Application Ref:	3/2026/0550			 Ribble Valley Borough Council www.ribblevalley.gov.uk	
Date Inspected:	N/A	Site Notice:	N/A		
Officer:	LW				
DELEGATED ITEM FILE REPORT:				Decision	REFUSAL

Development Description:	Prior notification for proposed agricultural track.
Site Address/Location:	Puddletown Field, Old Langho Road, Old Langho, BB6 8AW.

Proposed Track

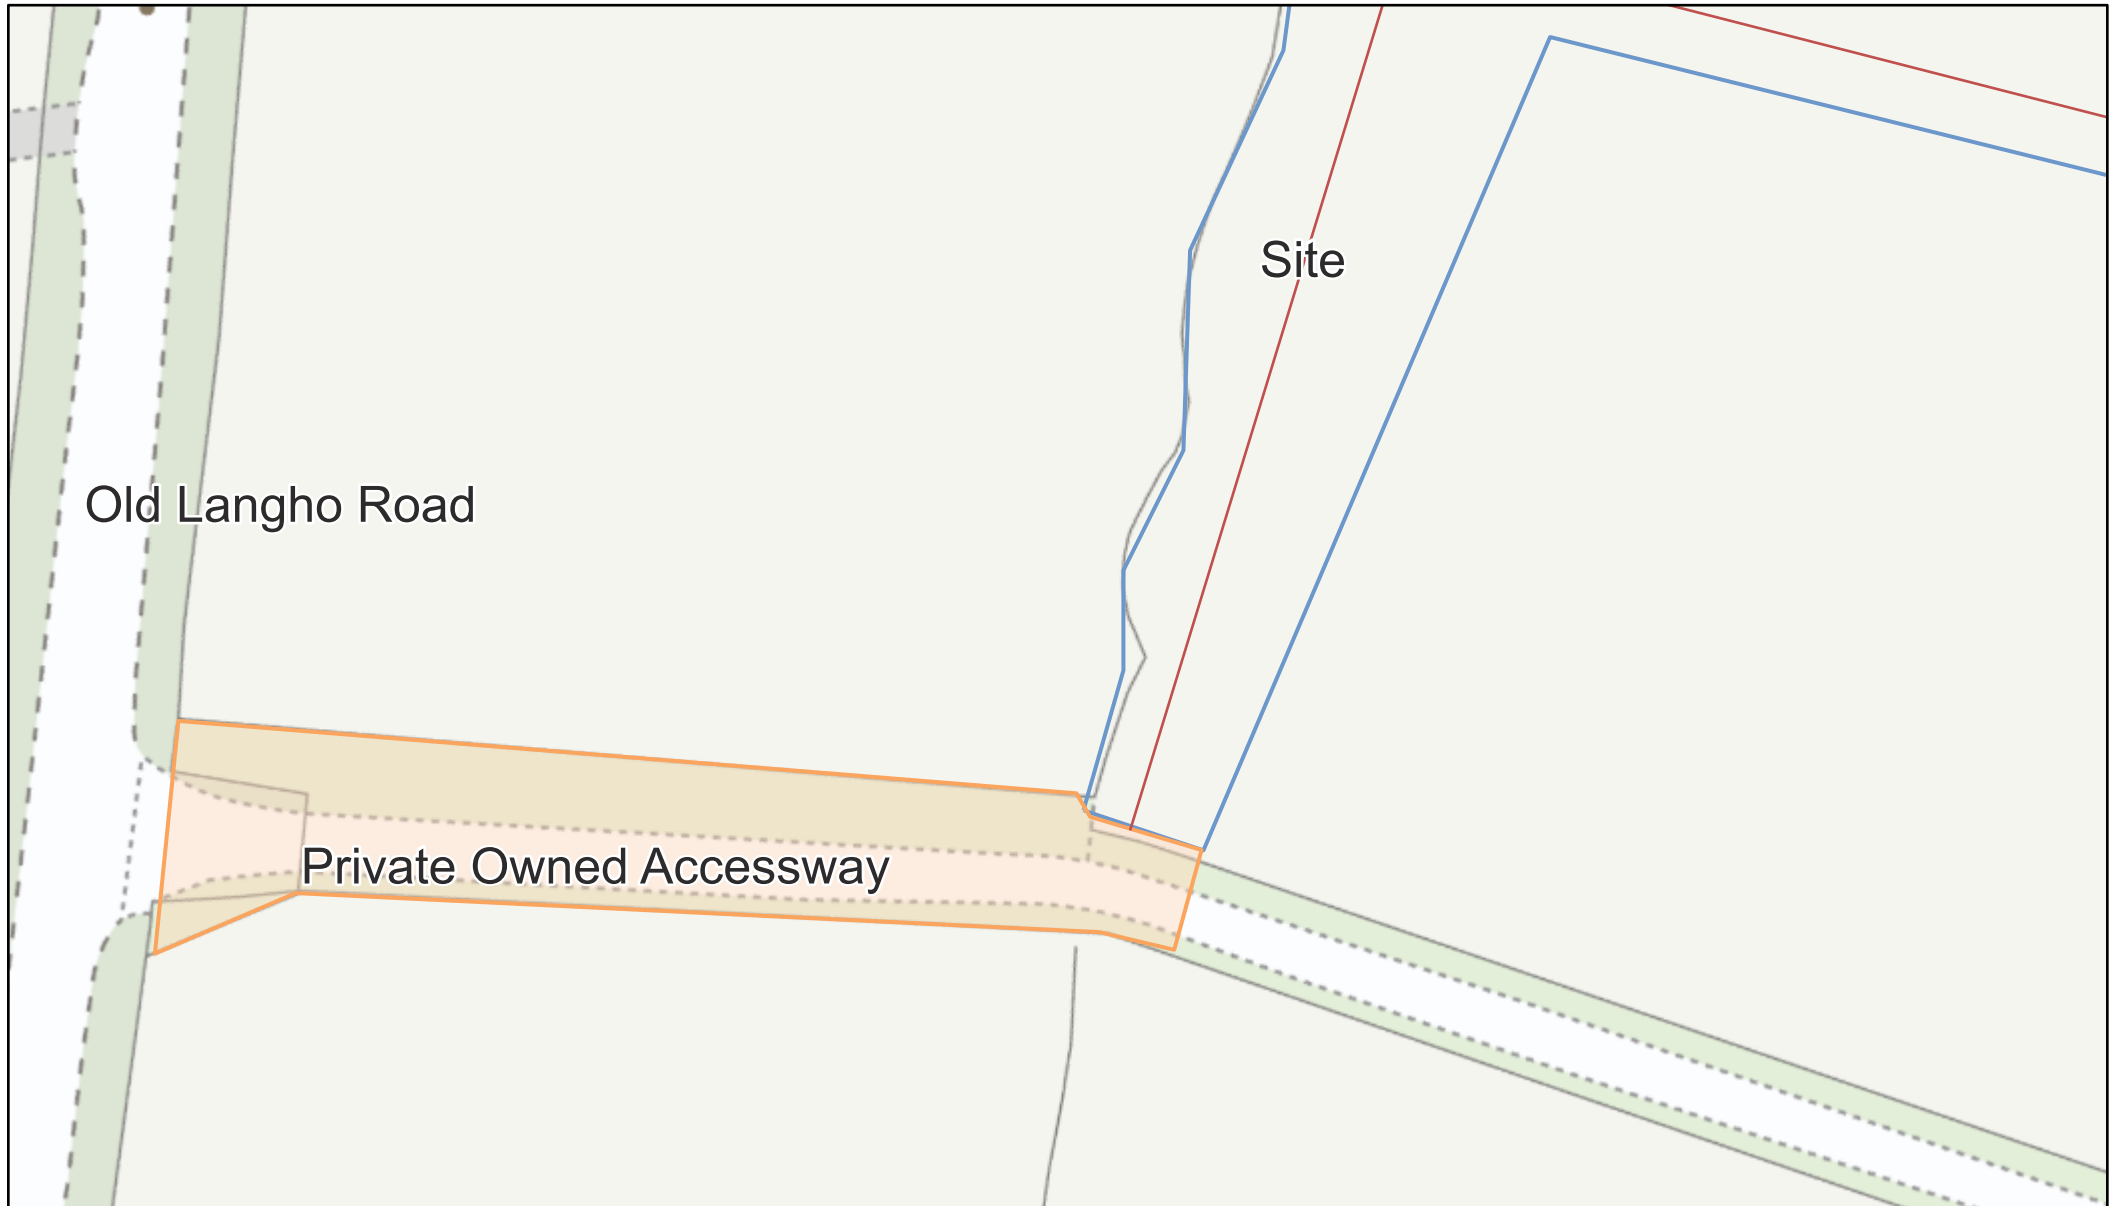
Whilst sections of the proposed track network would follow existing field boundaries, substantial lengths would extend across open and undeveloped fields. The proposed development would therefore introduce new built form, eroding the open and undeveloped character of the site.

Furthermore, for the reasons set out above, insufficient evidence has been submitted to demonstrate that the extent and alignment of the proposed track network are reasonably necessary for the purposes of an existing agricultural operation. In the absence of such justification, the Local Planning Authority considers that the siting of the development would result in unnecessary harm to the character and appearance of the countryside.

Accordingly, prior approval is refused in respect of the siting of the proposed development.

It is understood that the proposed track would comprise two parallel wheel-strip tracks, each approximately 0.4 metres in width, separated by a central strip of retained grass. The wheel strips would be formed using a flexible geocellular grid system filled with permeable local aggregate to a depth of approximately 150mm.

This is considered to be typical of agricultural tracks and, by reason of its relatively low-profile, would not give rise to concerns regarding the means of construction of the development.
